Our Ref: 3154
Your Ref: SSD-82548708

7 July 2025

**State Significant Development Application for Residential Flat Building with Infill
Affordable Housing 24, 26 & 28 Middle Harbour Rd**

Peter Cinque
Senior Manager Emergency Risk Management
NSW State Emergency Service

BASEMENT 2
1:400

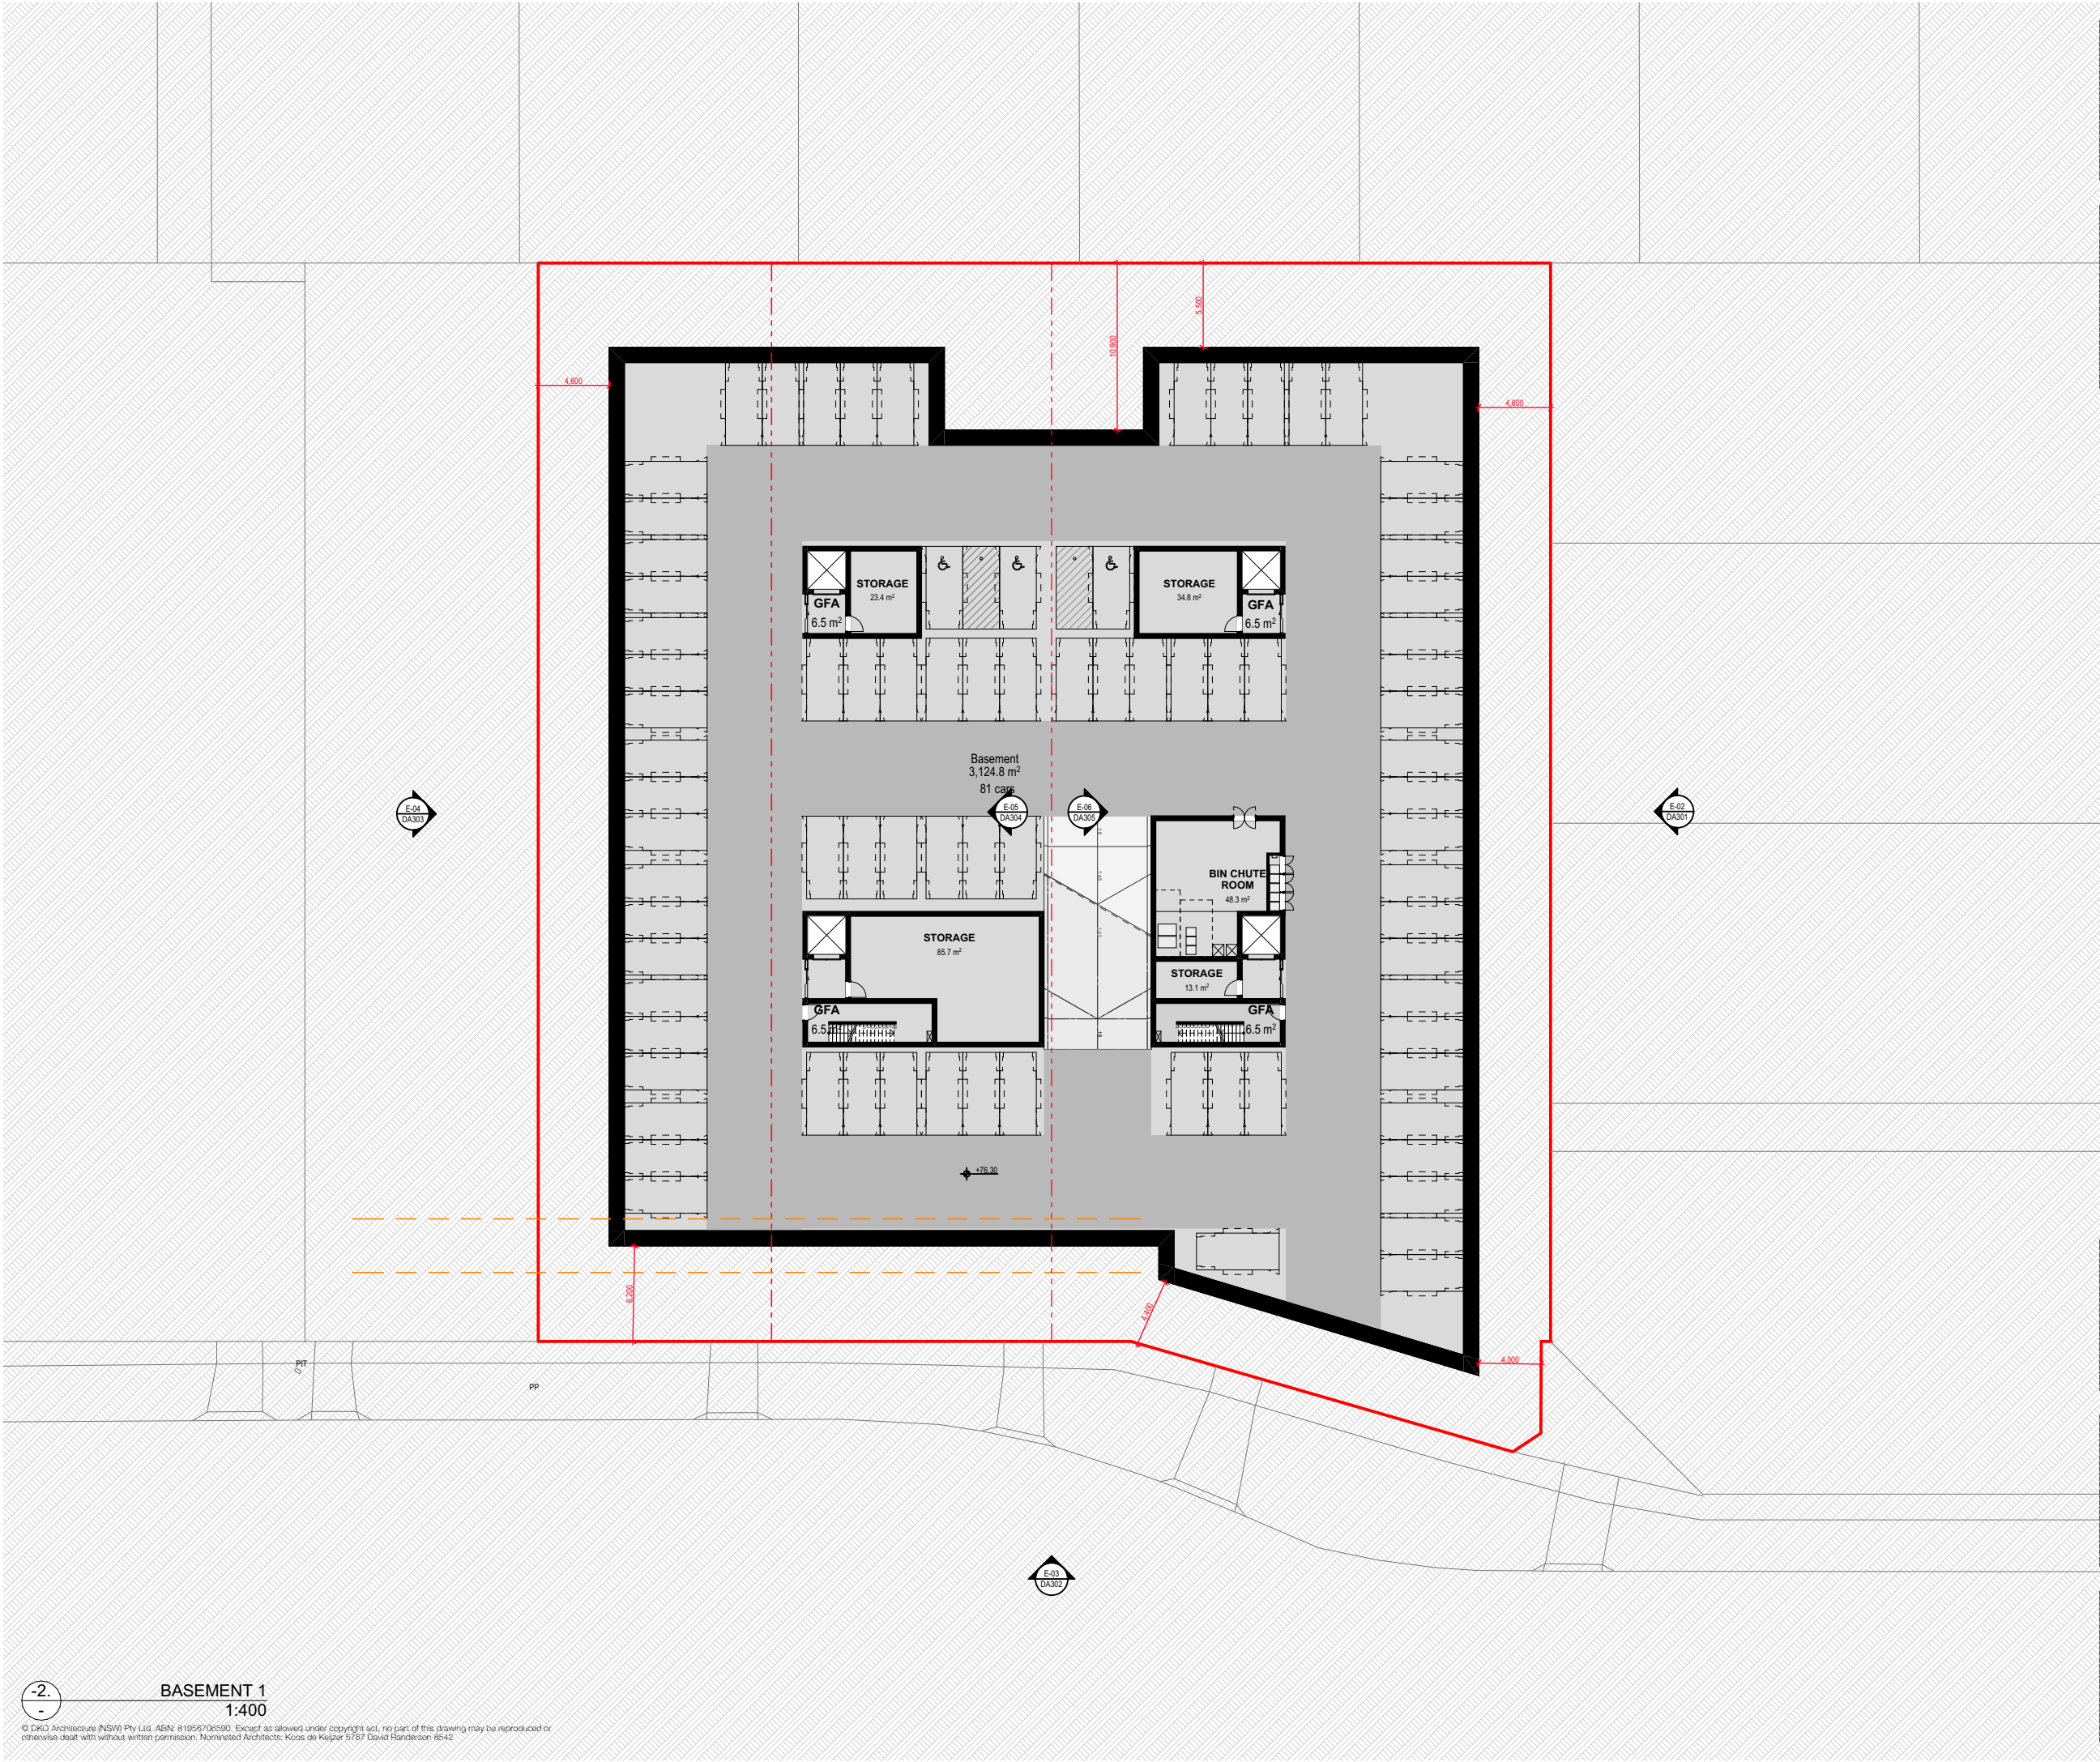
- **Recommend** ensuring that all openings to the basement (ramp, vents, etc) are situated above the PMF, or reconsidering basement carparking if this is not feasible, to reduce risk to life and property.

Basement car parks have inherent risks to life and property²⁵ and can often restrict safe evacuation of the occupants. This can be managed through building design, such as crest levels above a certain level (e.g. the PMF) to prevent water ingress and flooding.

Building designs which put cars or other property under the building may also encourage people to take risks to save these items, and therefore is not preferred for future development that sees an increase in the number of people exposed to the risks.
